SUBMISSIONS REPORT

Alexandria Health Centre

SSD-38600121

Indicative Concept Plan / Ground

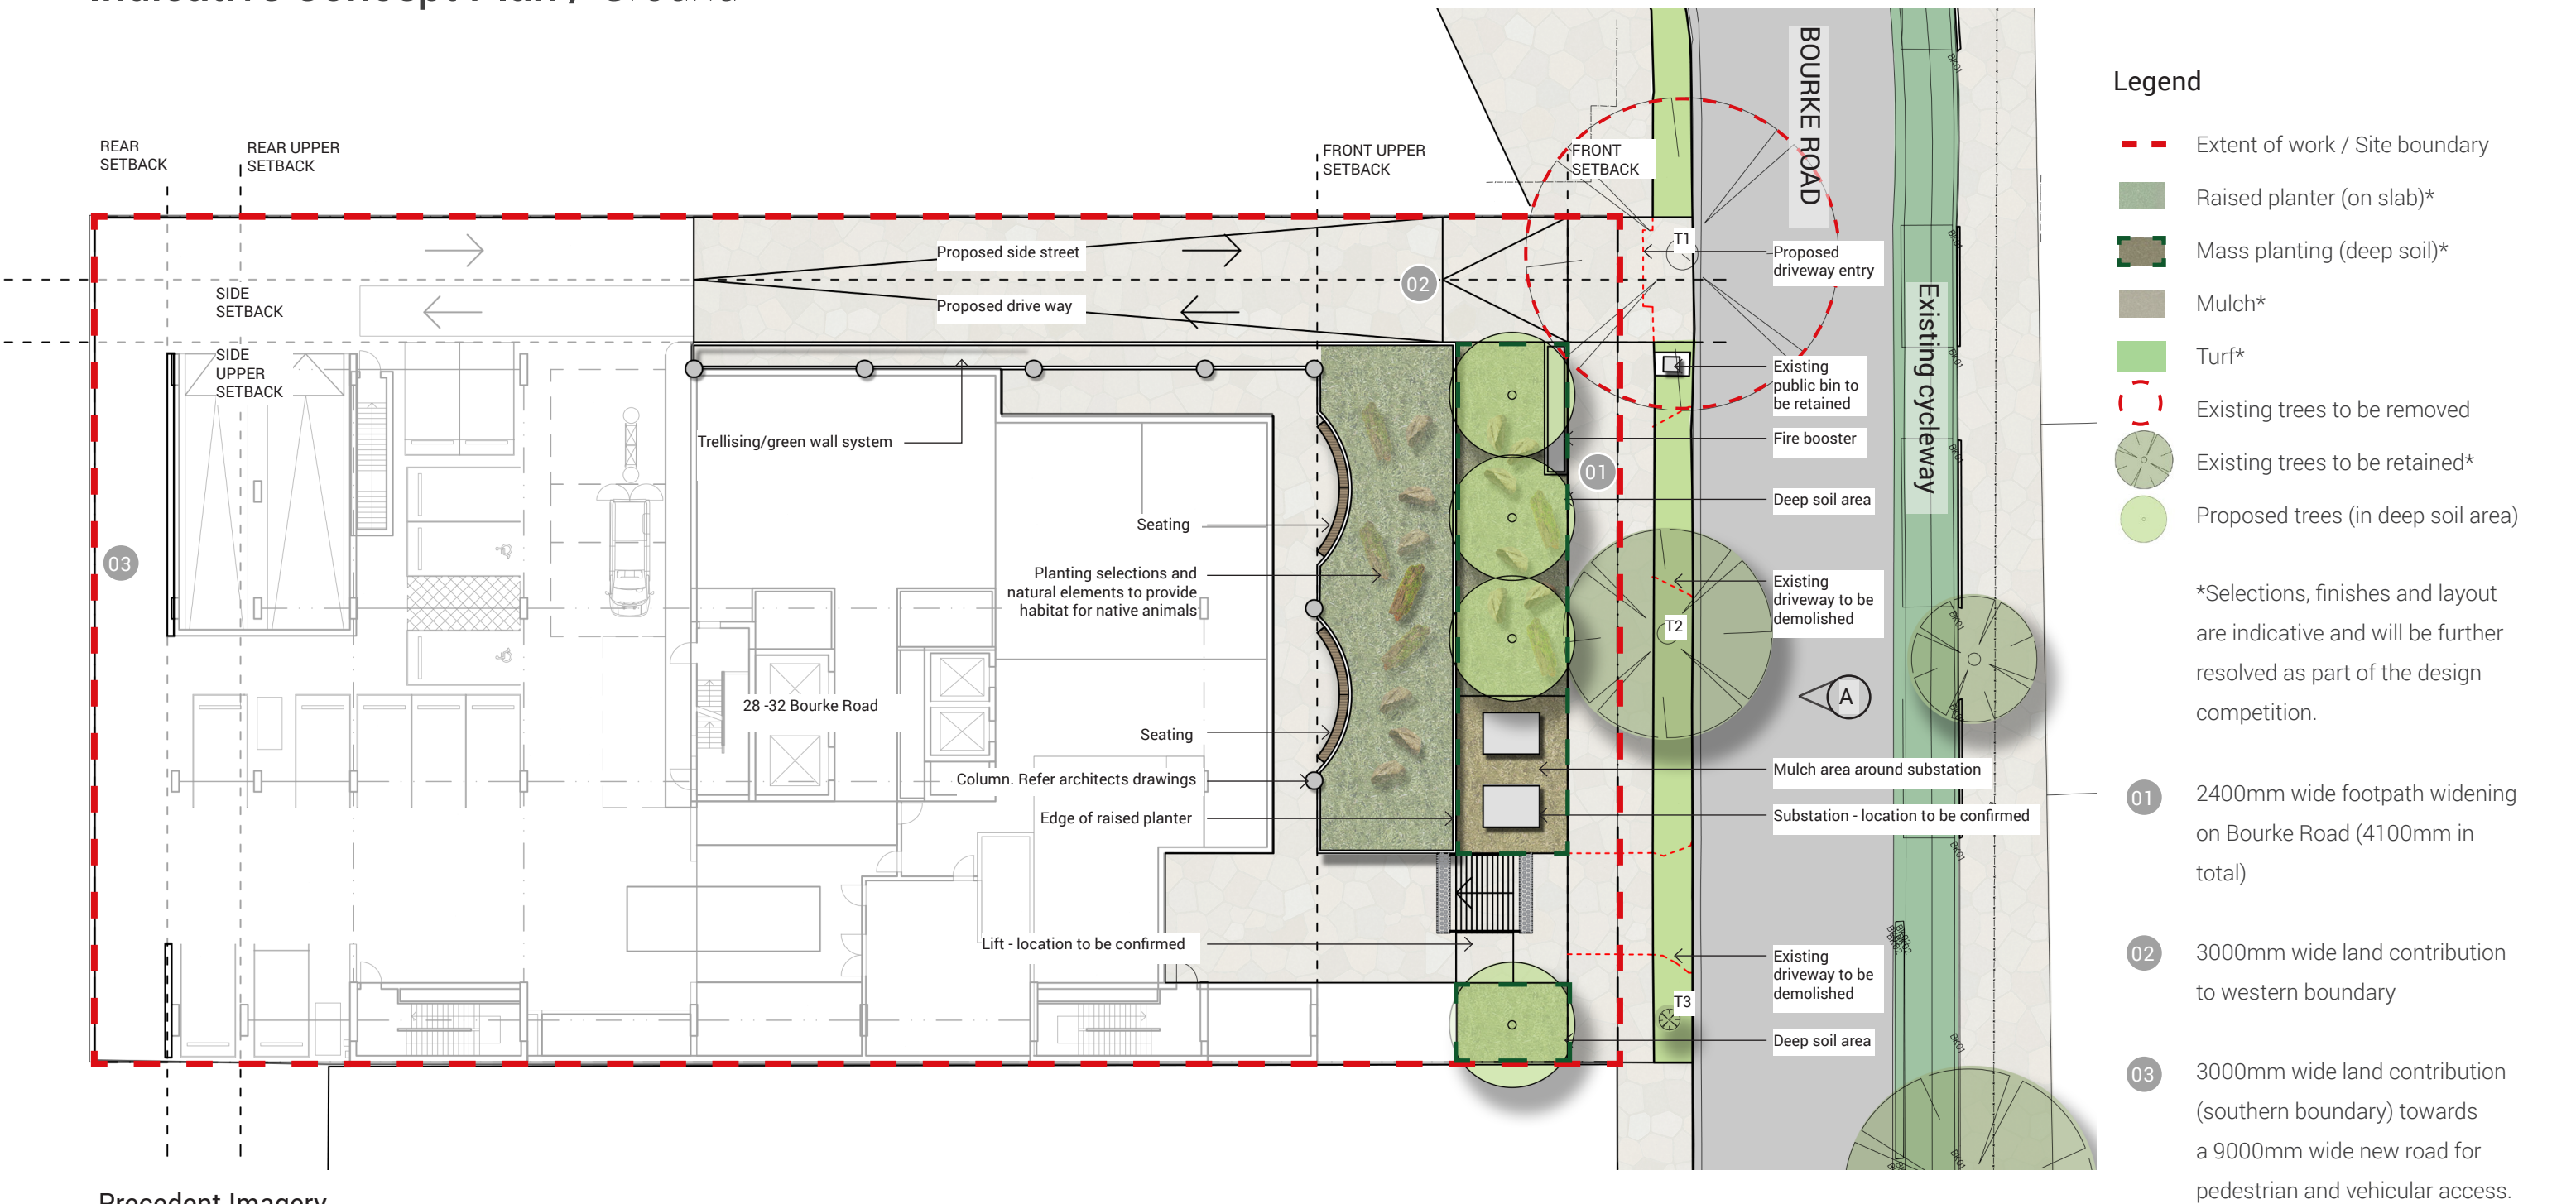
<p>Landscape strategy</p> <p>It is recommended that the supporting landscape strategy (Appendix K) be updated to relate to the amended envelope. It notes areas of deep soil, locations of communal open space and setbacks.</p> <p>When this is updated, it is recommended that the landscape strategy be attached to the design competition brief and a condition be imposed on the concept SSD to reference the landscape strategy.</p>	<p>Noted and accepted</p> <p>Levels, planting and construction details have been removed from the Landscape package and a landscape strategy has been prepared, refer to Appendix E.</p>
